**From:** Farhad Khatibi  
**Sent:** 29 September 2025 13:13  
**To:** Planning ContactCentre  
**Subject:** RE: Attached letter from Kirklees Council regarding application number 2025/92674 at location Land North of, Denby Lane, Grange Moor, Huddersfield, WF4 4BH

Further to the discharge application in connection with the above, I would like to offer the following comments in relation to planning conditions 15 (surface water attenuation system) and 33 (boundary treatment).

TITLE  
**S15 FLOW CONTROL MANHOLE DETAIL**

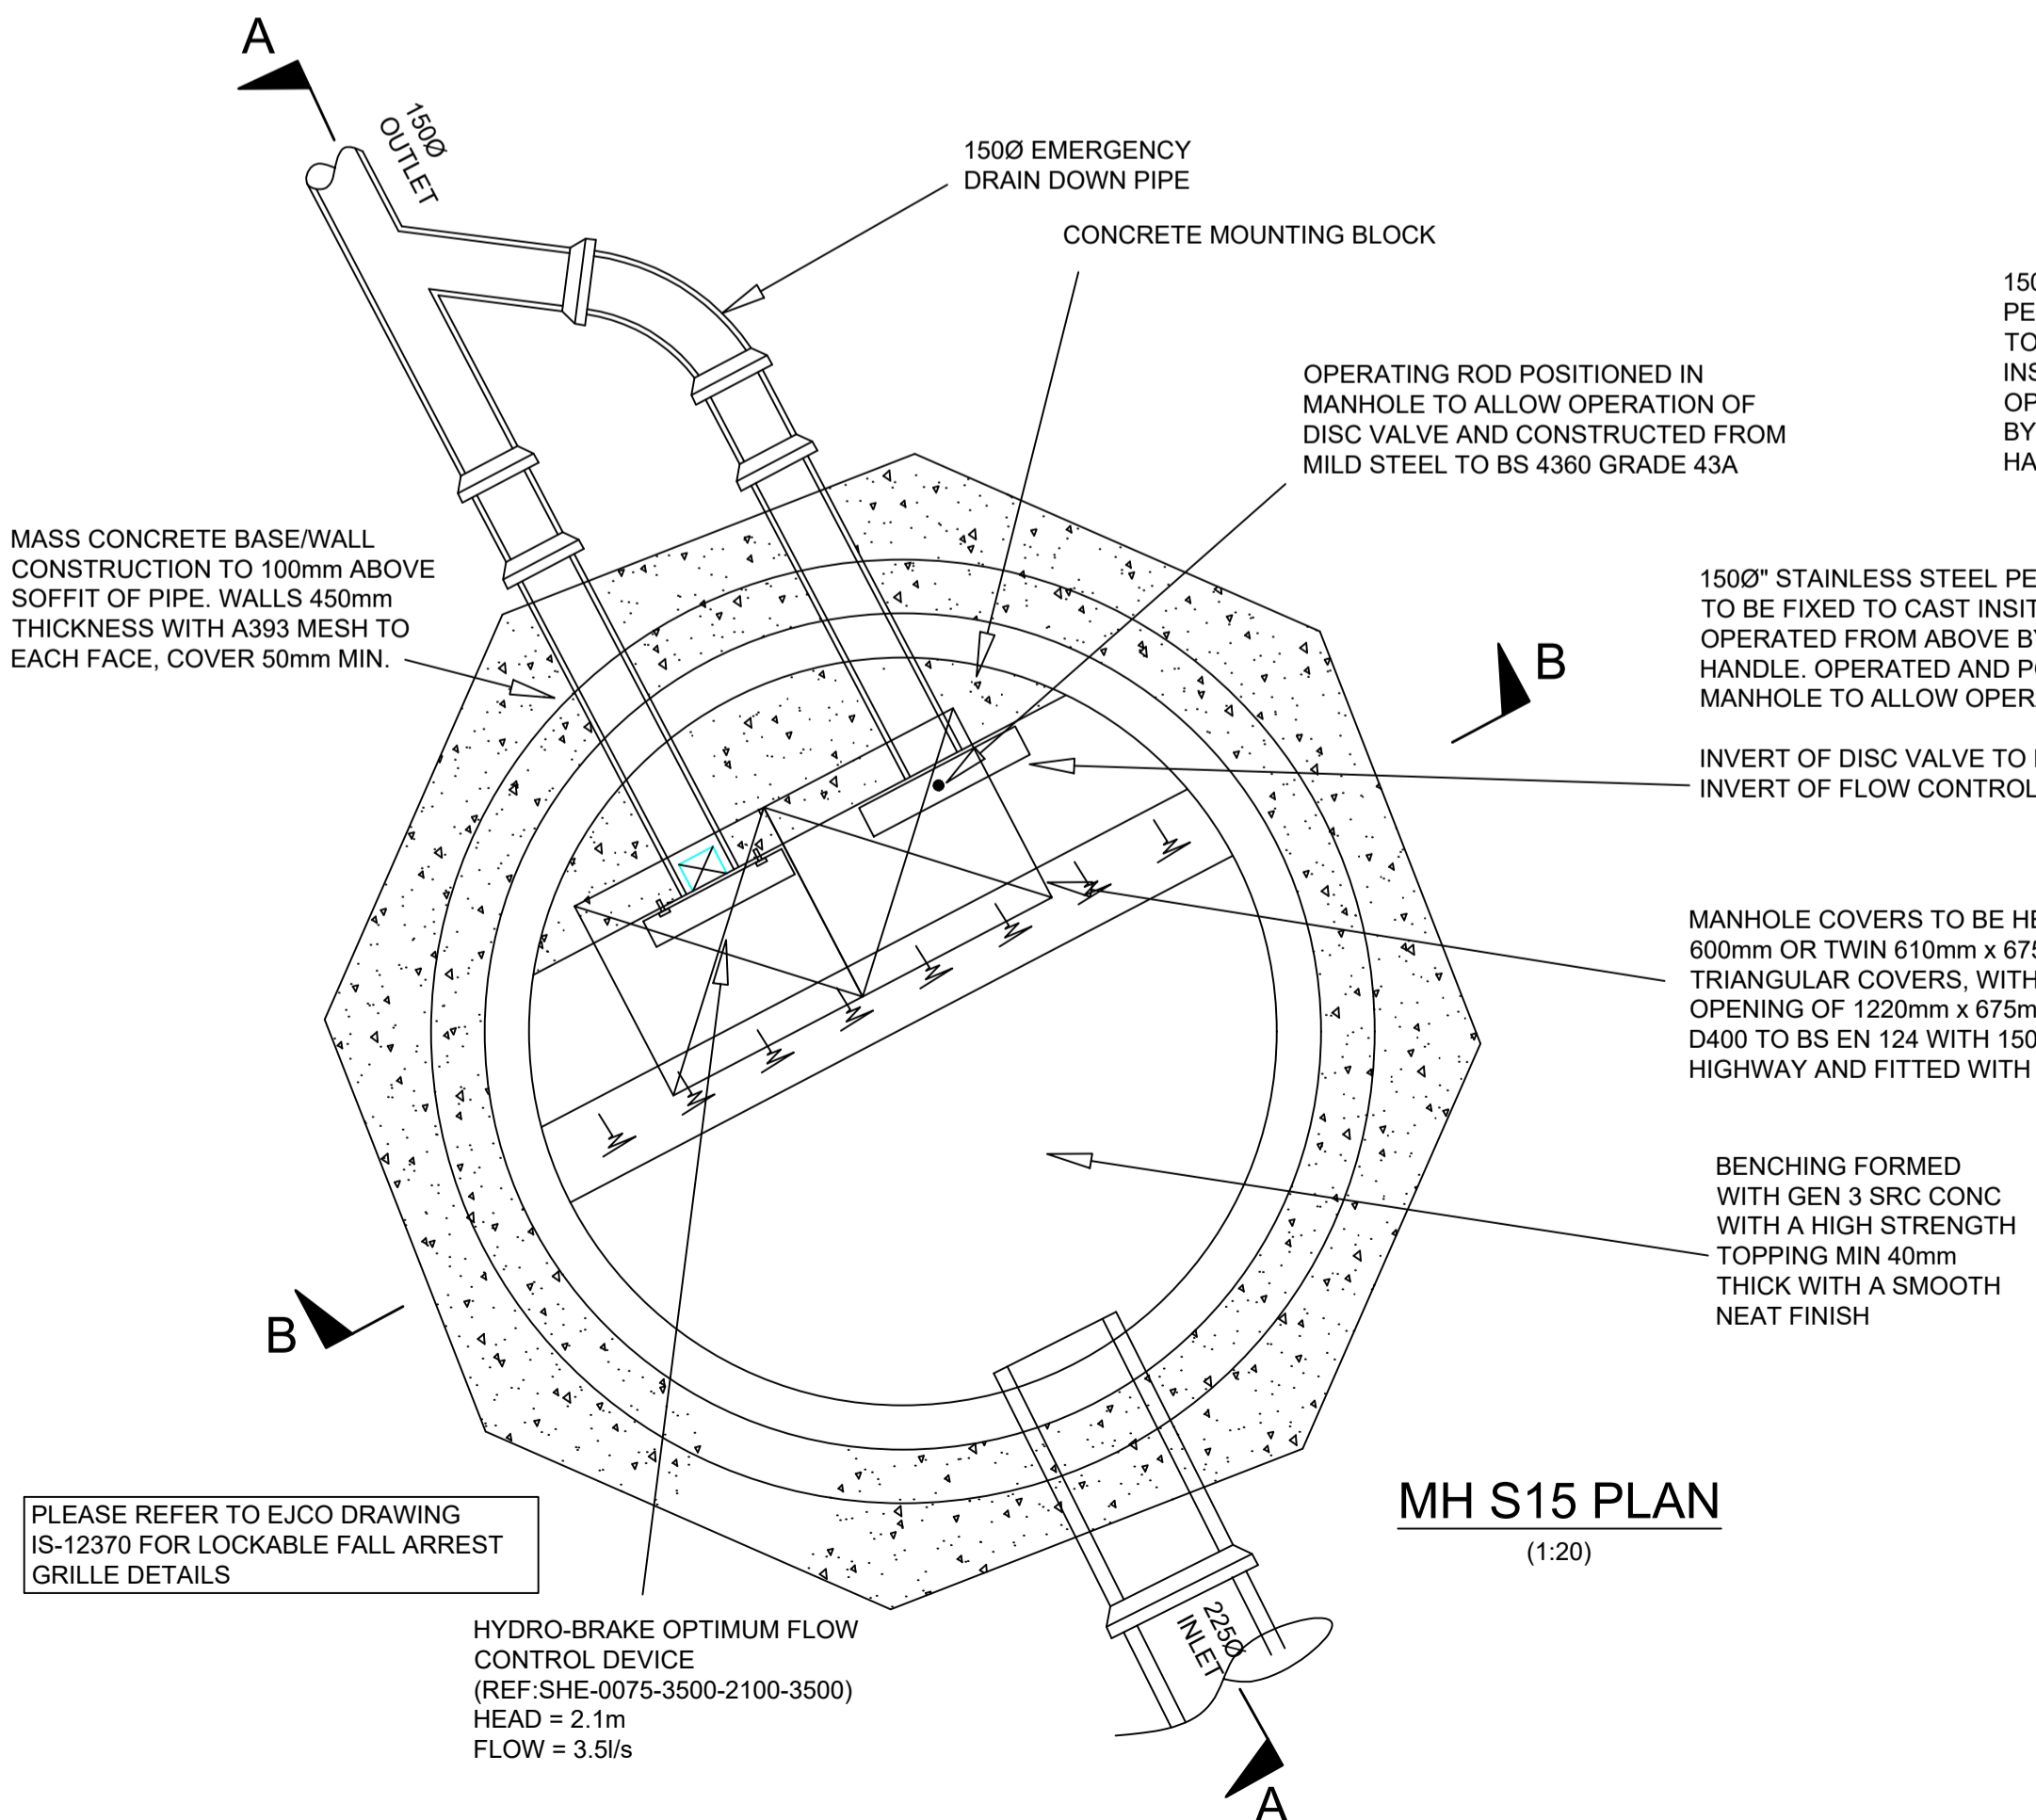
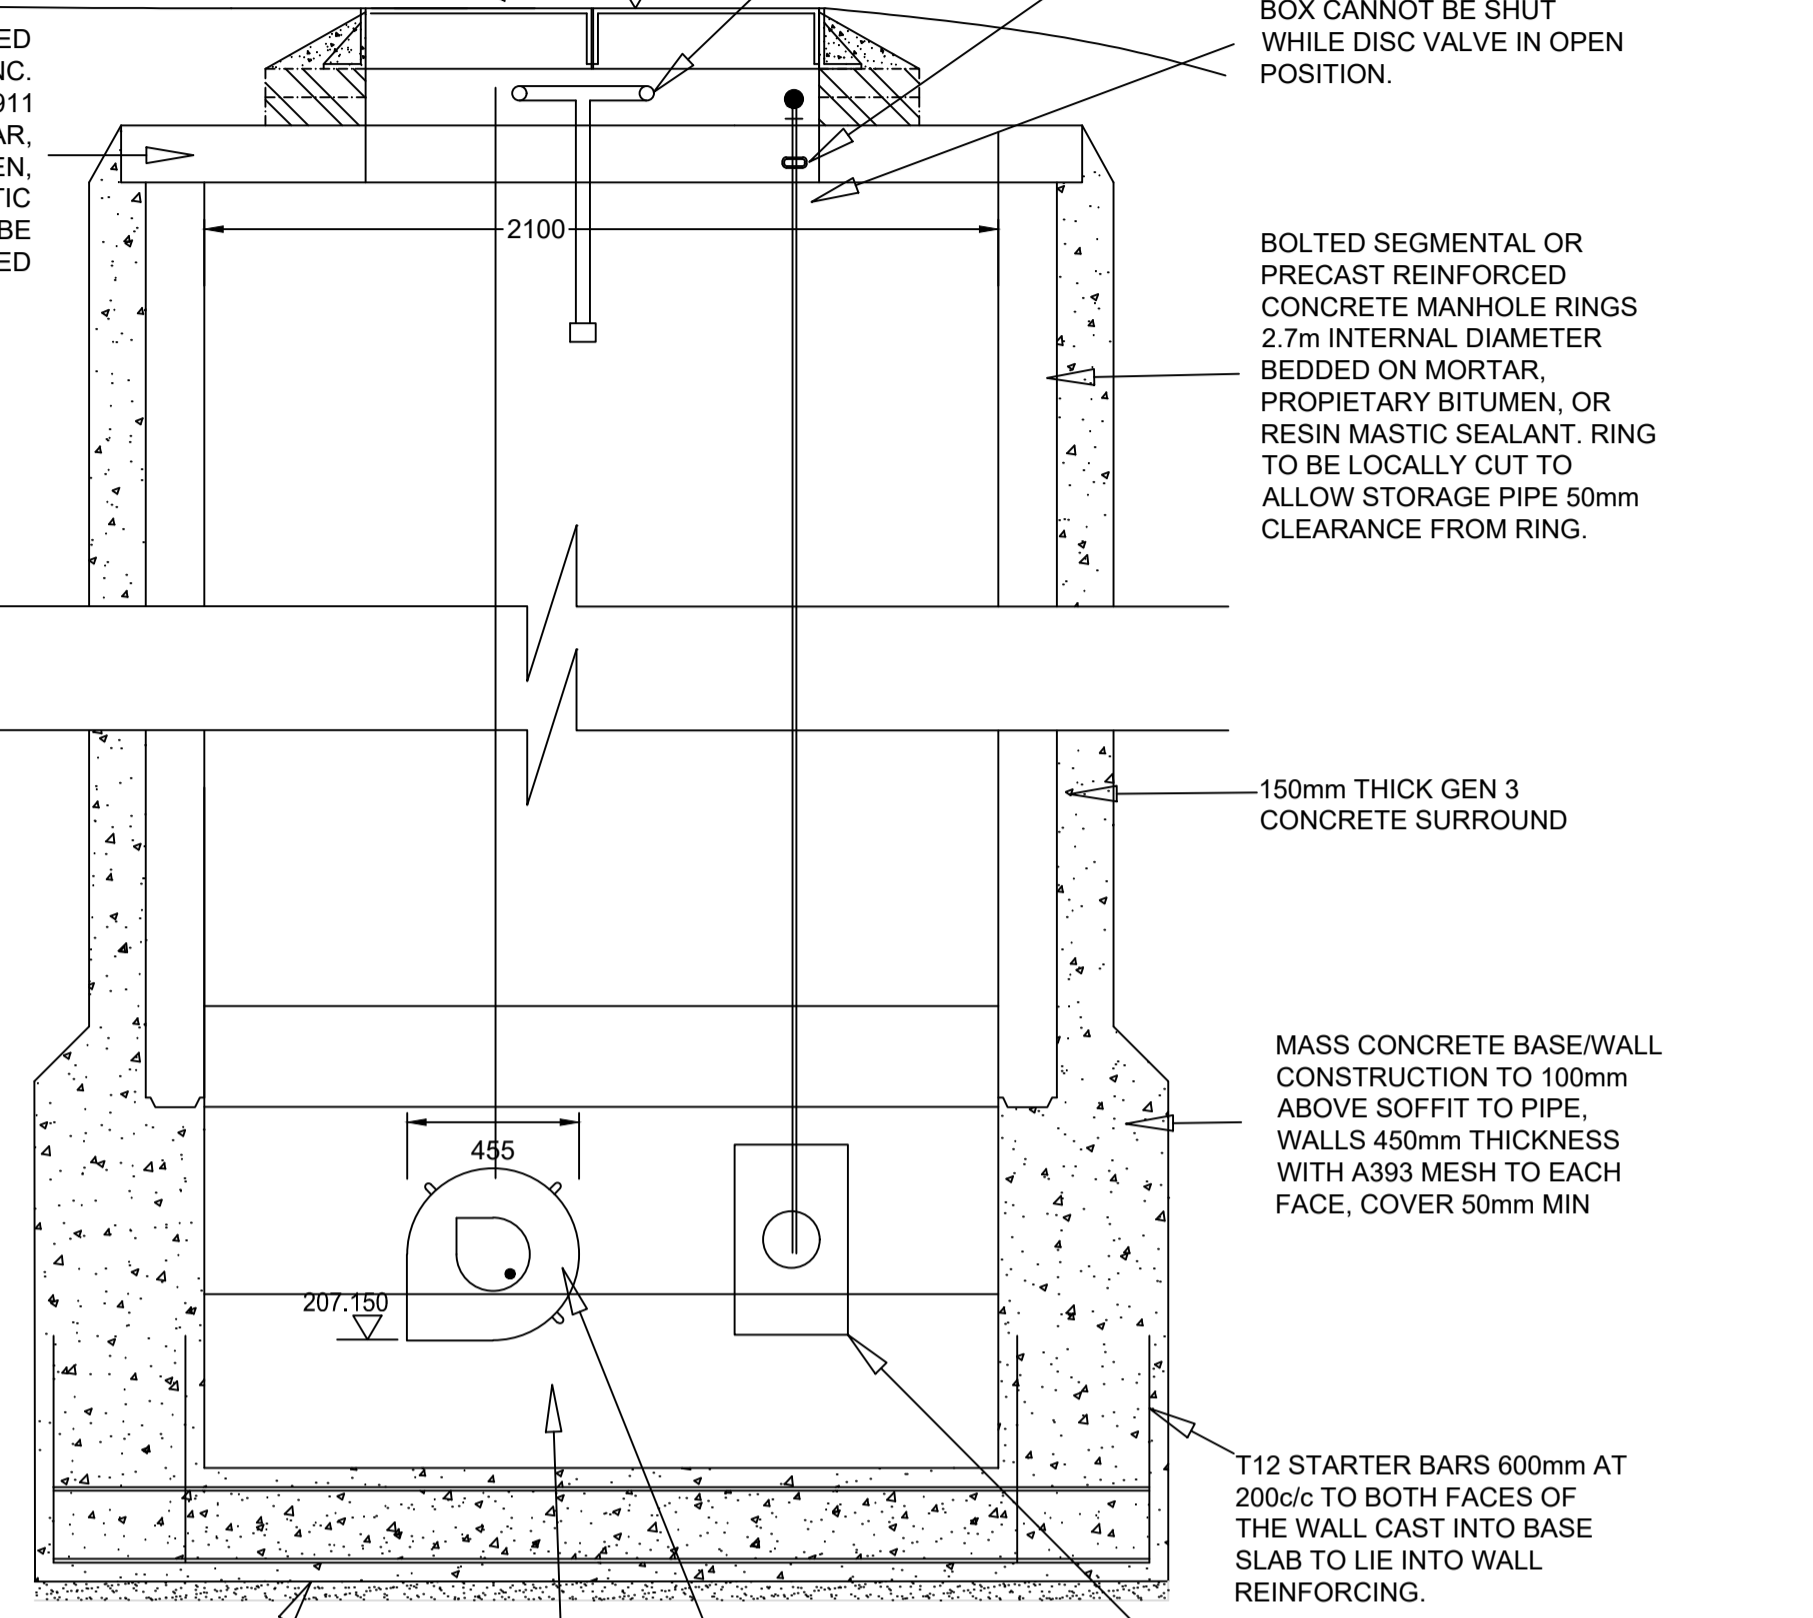
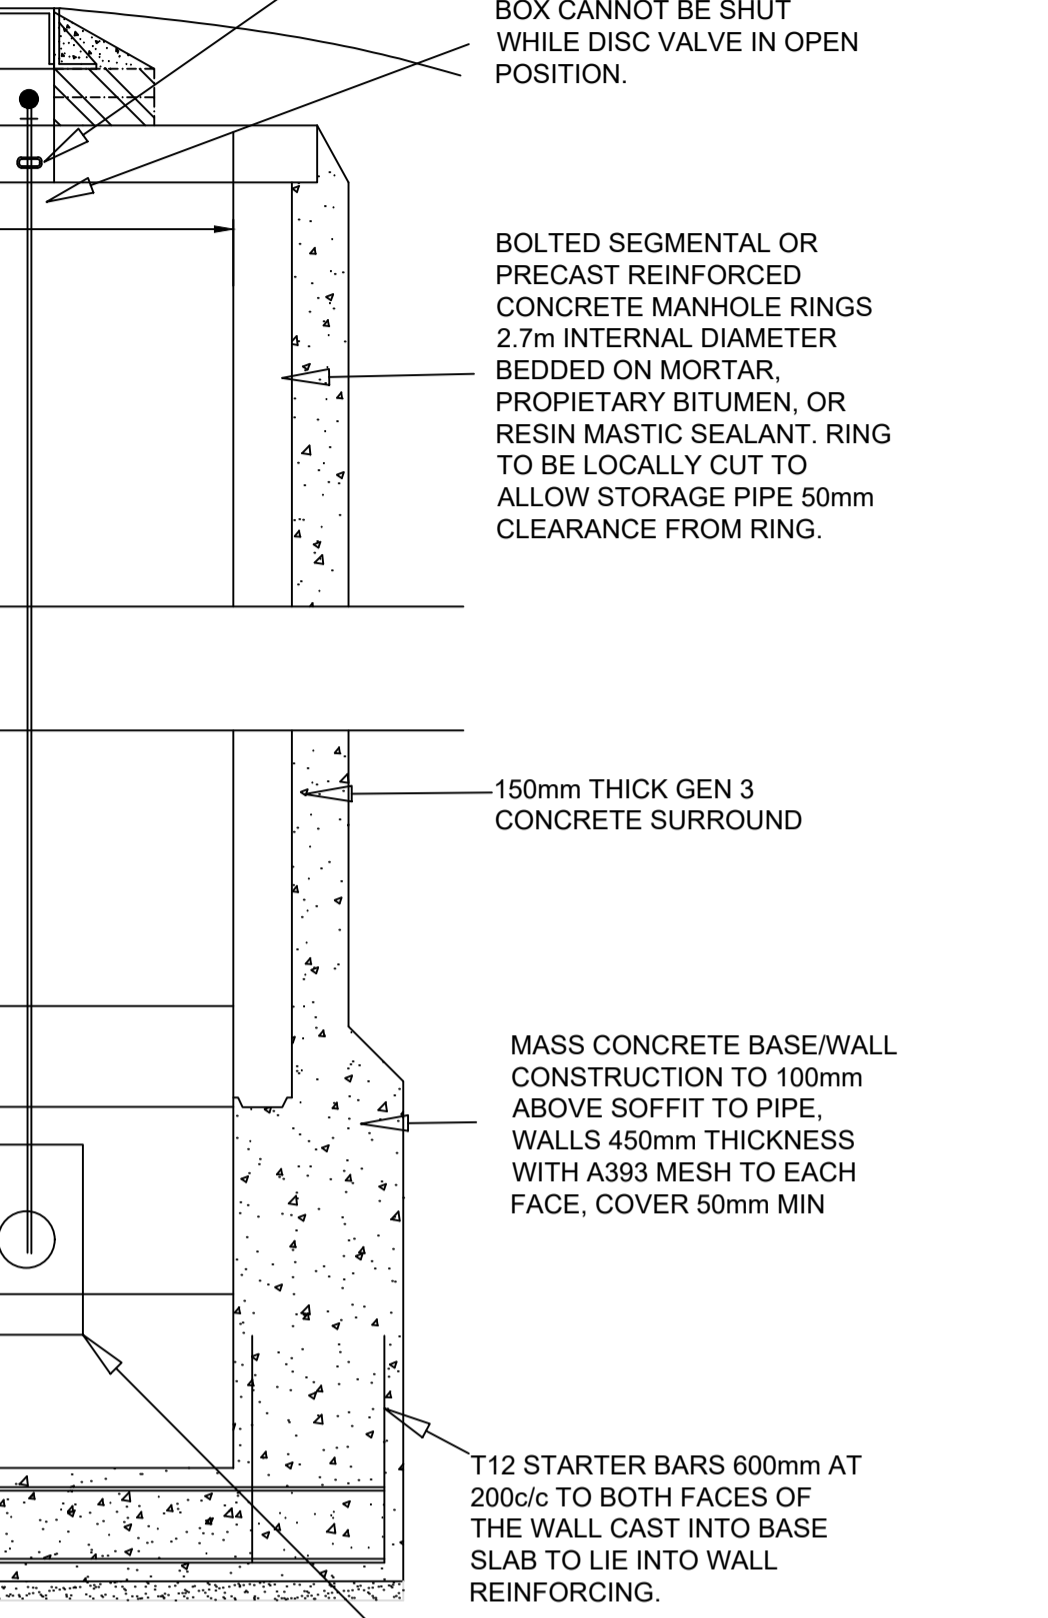
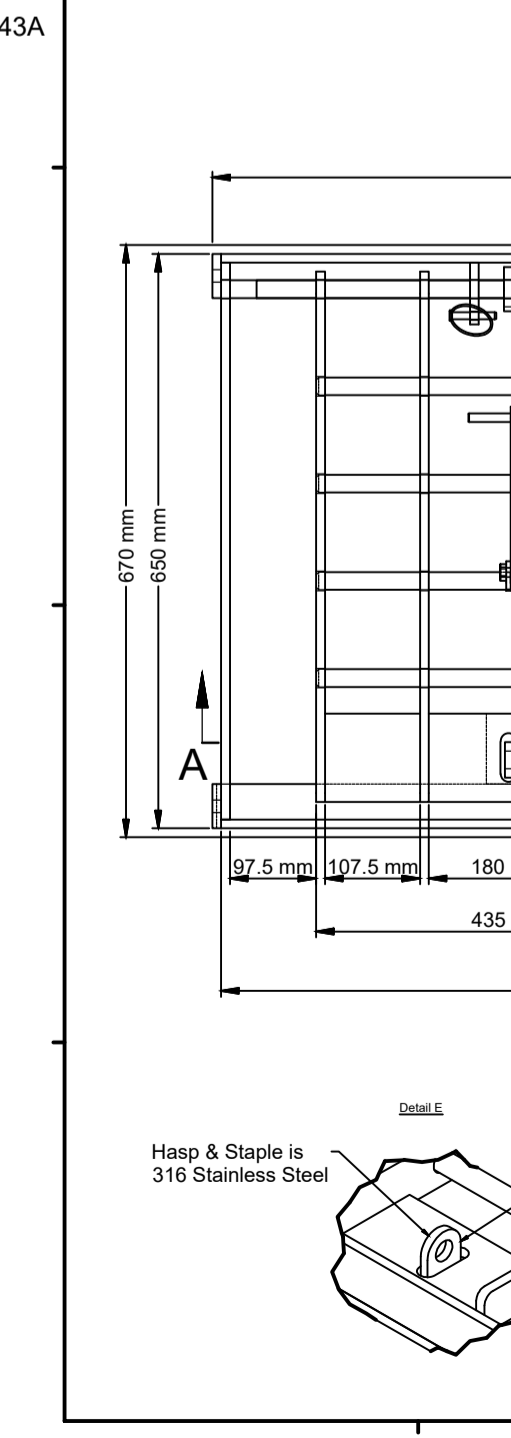
**Condition 15 (surface water attenuation system)-** This condition can not be discharged pending the satisfactory conclusion of the technical approval of the design of oversize manholes located in the highway, for which a fee of £371.00 (Cat 0 Structures) will be applicable.
